Rep on FP/193/17/HH

Planning Application FP/193/17/HH
Proposed Extensions to property at 5 Roundle Avenue, Felpham

Proposed North Elevation

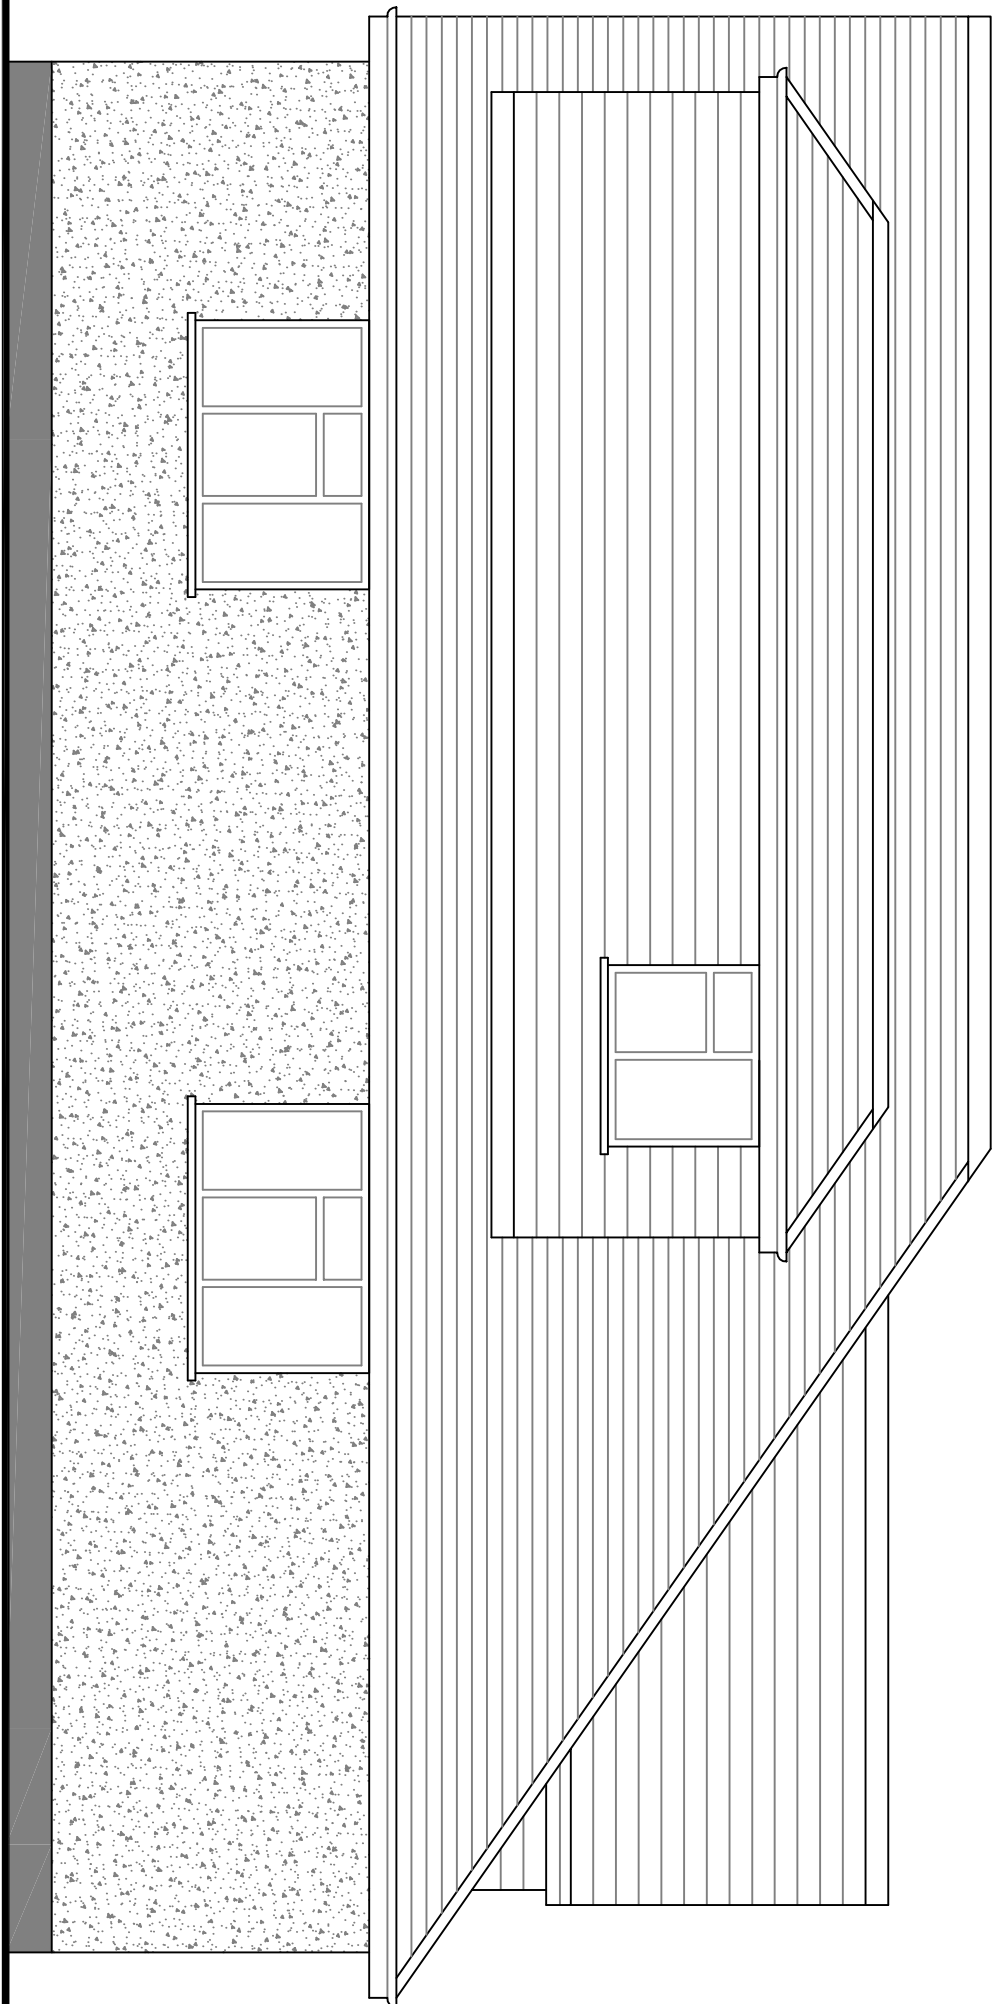
In an effort to avoid absolute negativity, the new design of front (East elevation) and back (West elevation) would be much more in keeping with existing buildings WITHOUT the 'boxed' appearance of the 'dormer' additions on the North and South elevations. (Use of Velux instead would compensate and allow additional daylight to the occupants).

Proposed Ground Floor Plan

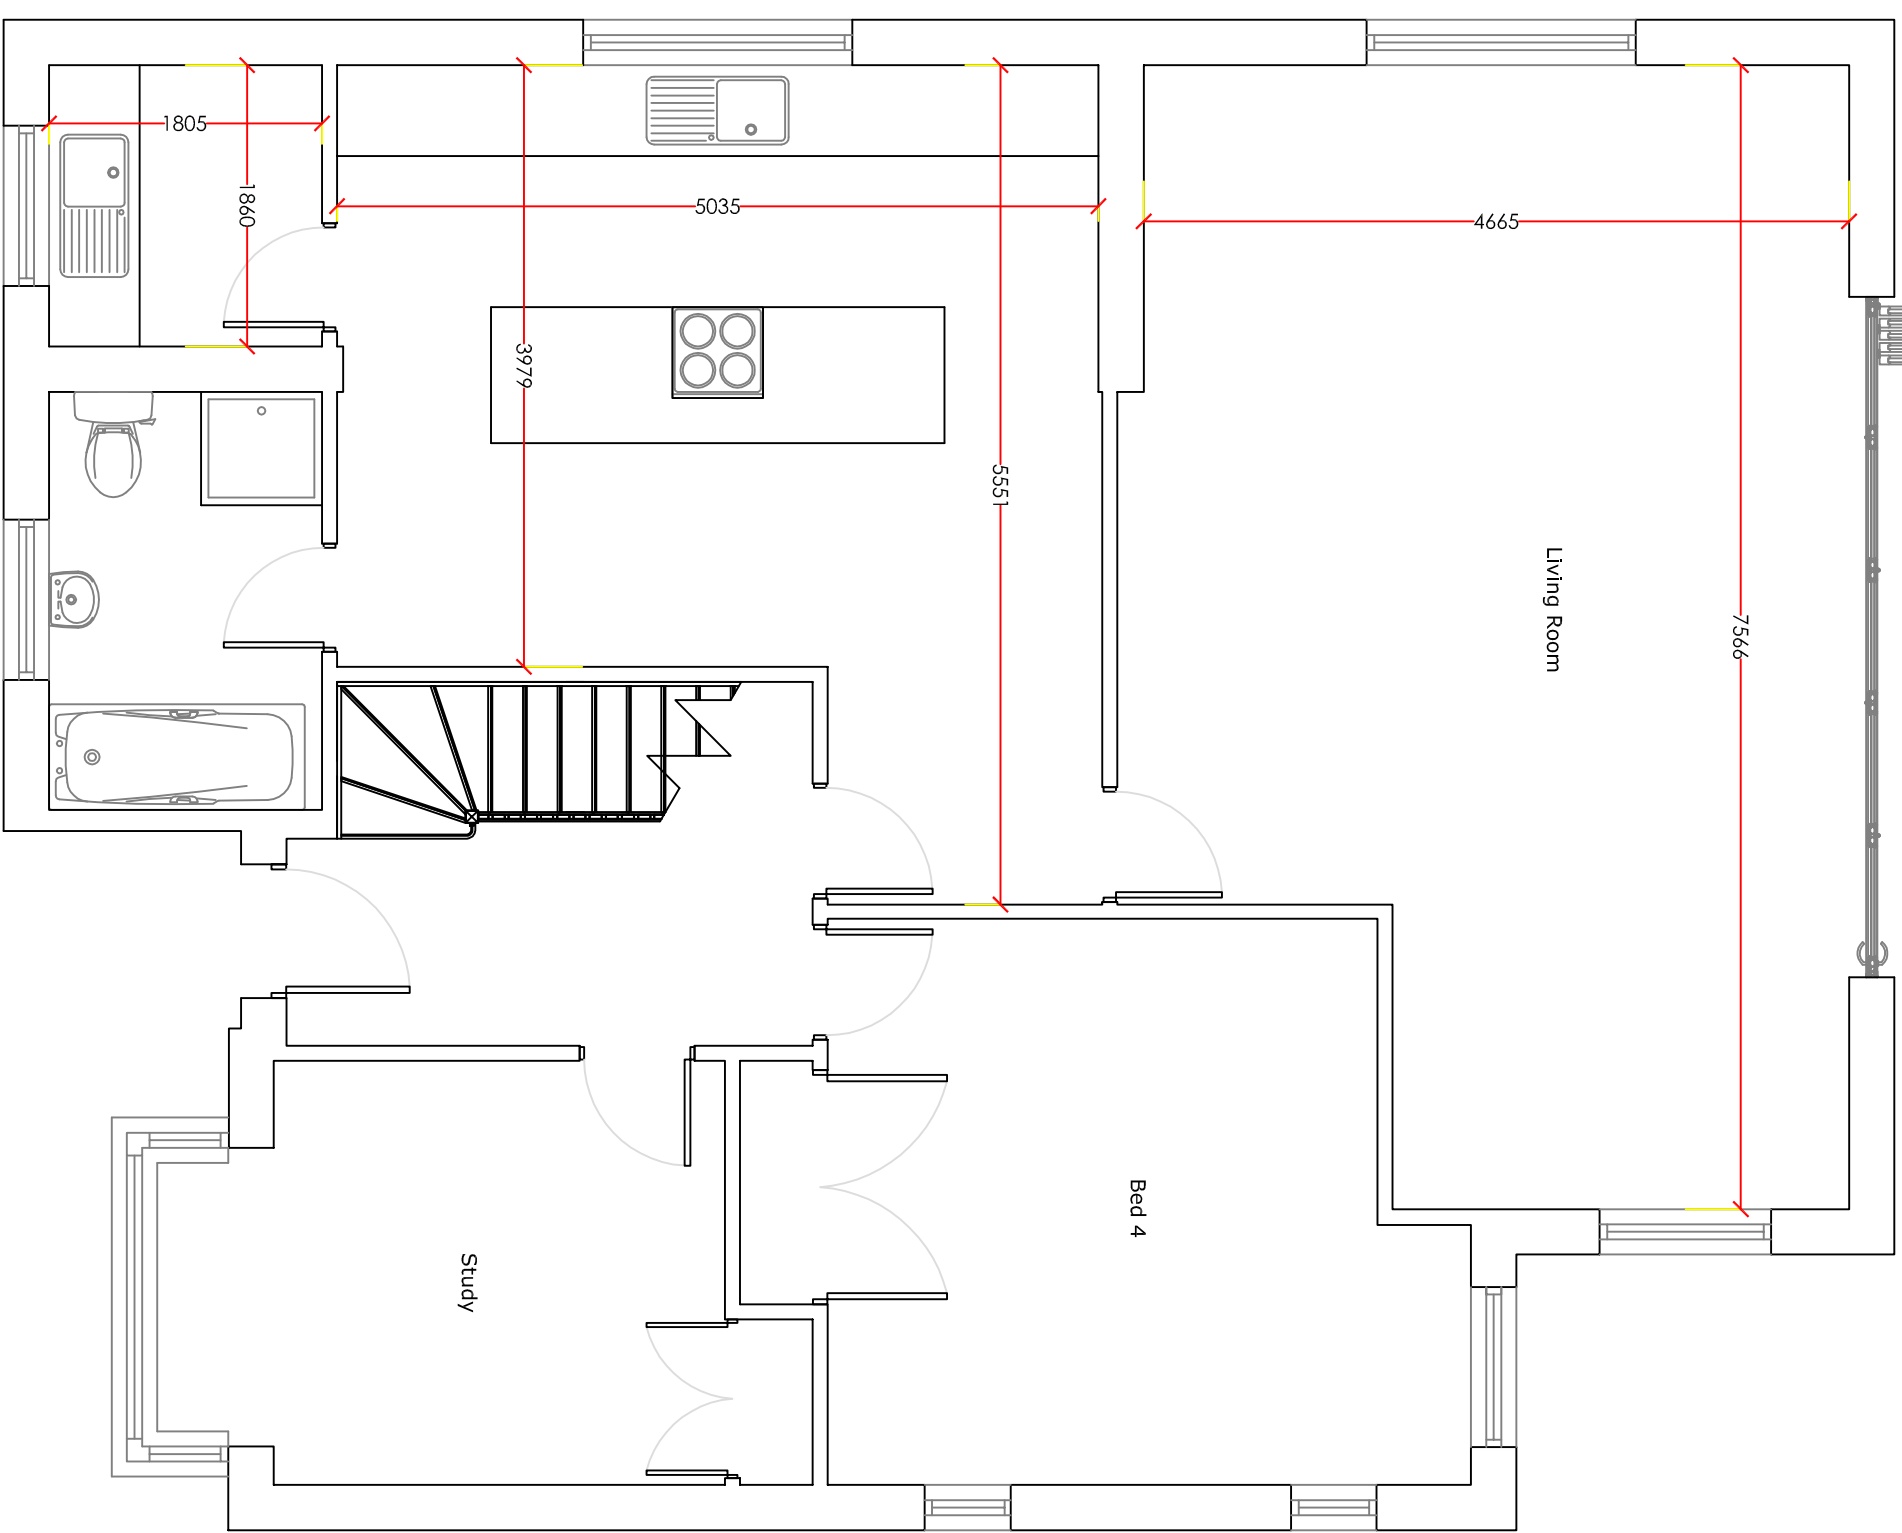
The current plan shows a bathroom, on the ground floor, with bath, shower, washbasin and TOILET leading directly from the kitchen. This seems unhygienic!

Proposed Ground Floor Plan

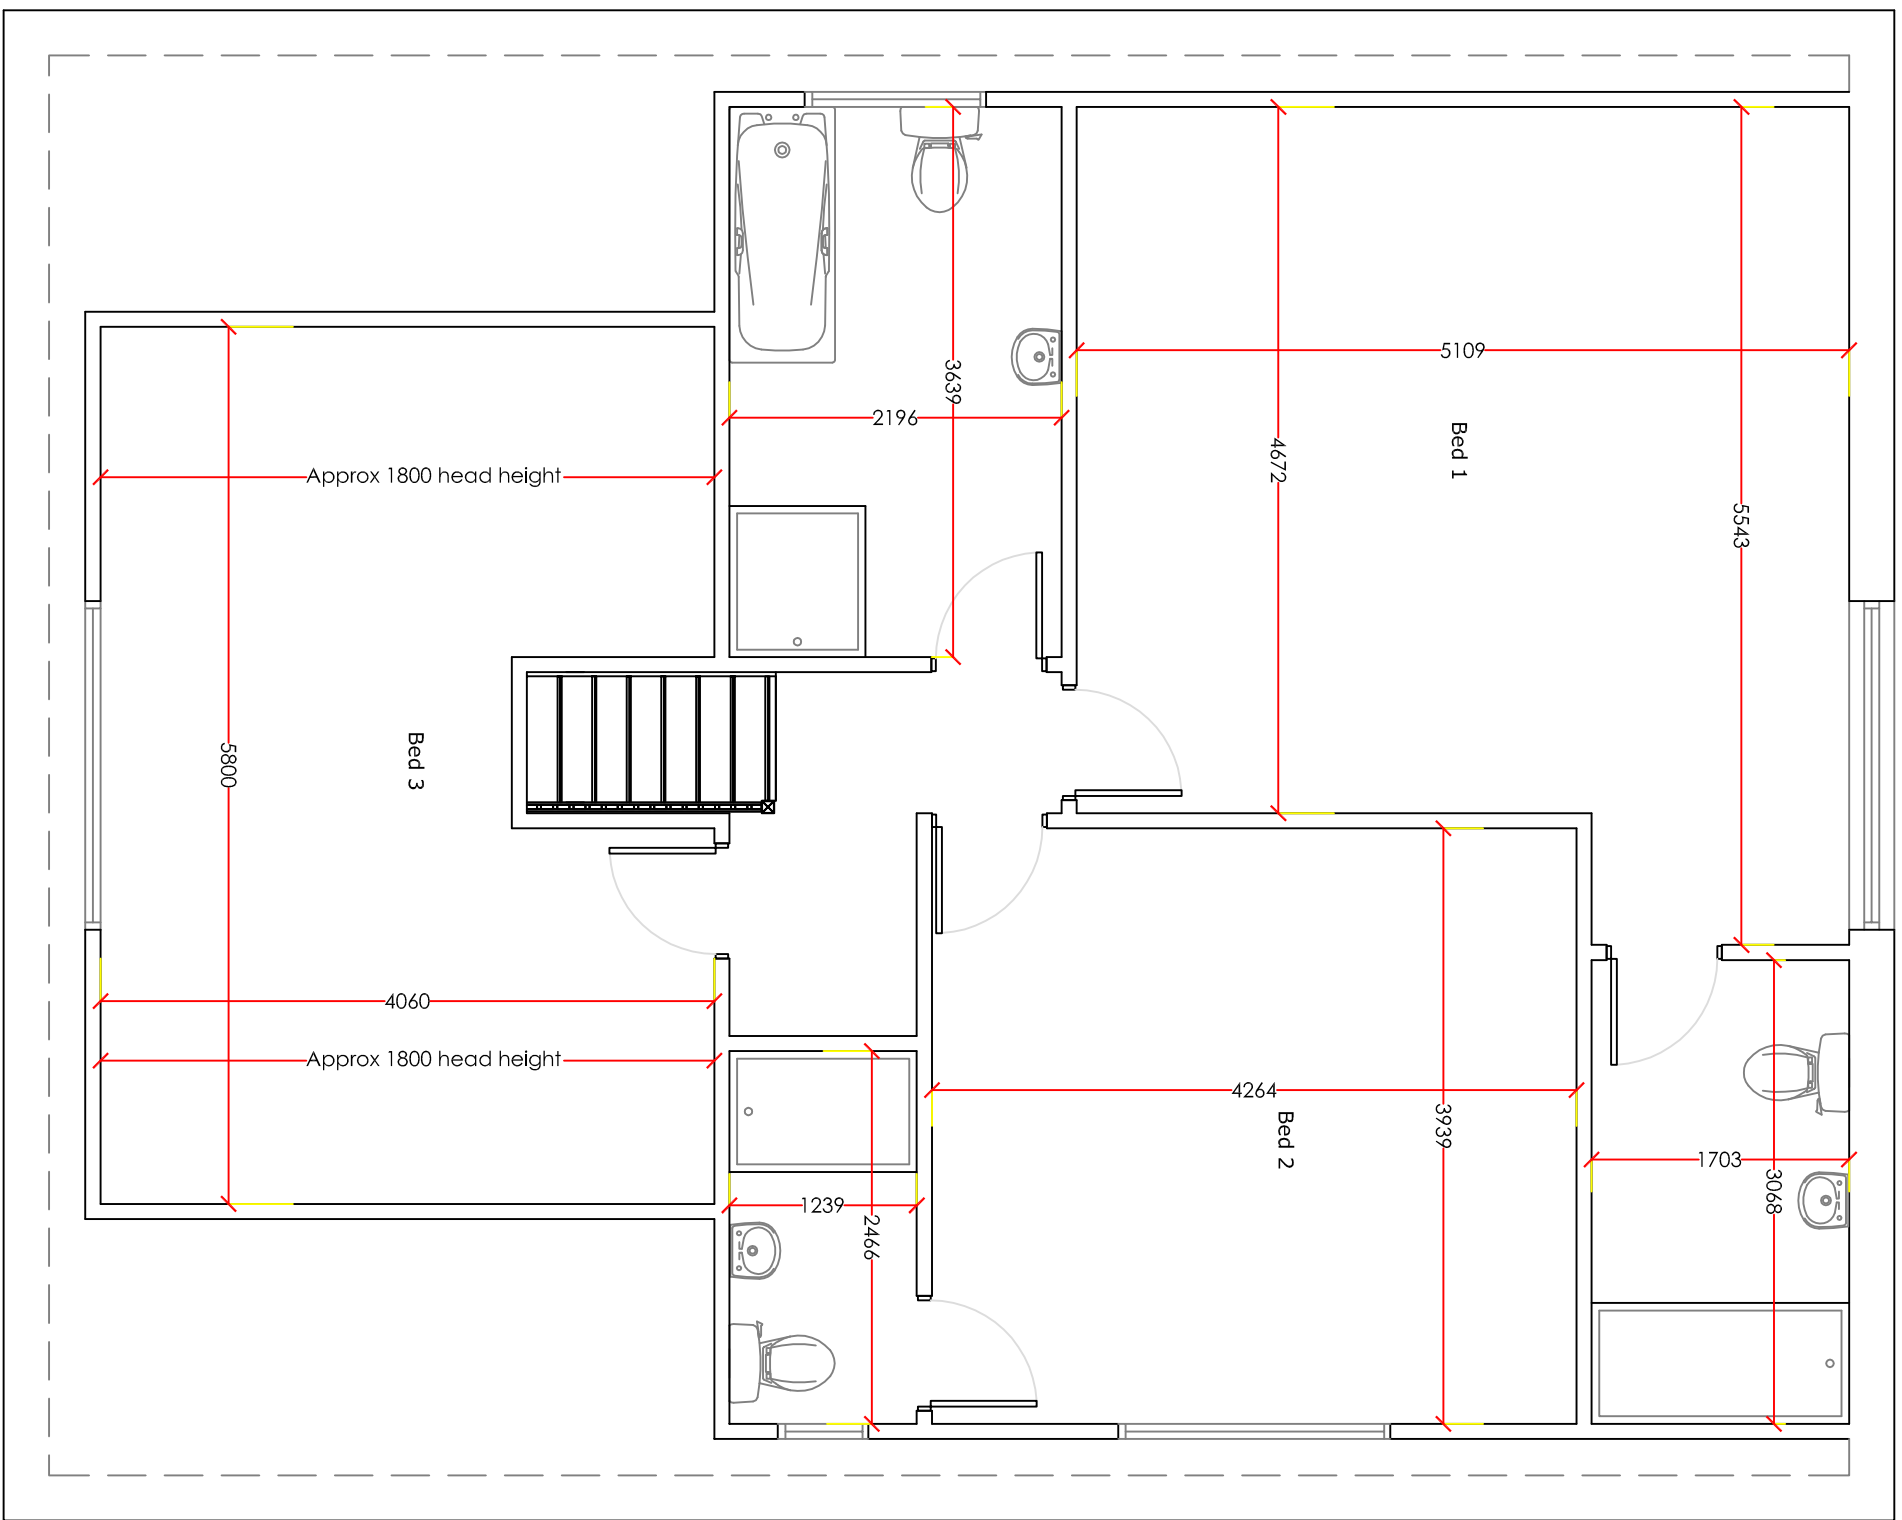
The plan submitted has 2 'proposed ground floor plans'. Obviously, the one on the right should have read 'proposed first floor plan'.

The plan shows bedroom 4 on the ground floor with windows directly facing continuous 'floor to ceiling' double glazing. This is also the case with the north facing window in the living room, although, in this case, the window is 1.8m further away. The first floor appears to propose building over this space. This indicates that the first floor will go beyond our building line with an unacceptable intrusion upon our privacy.
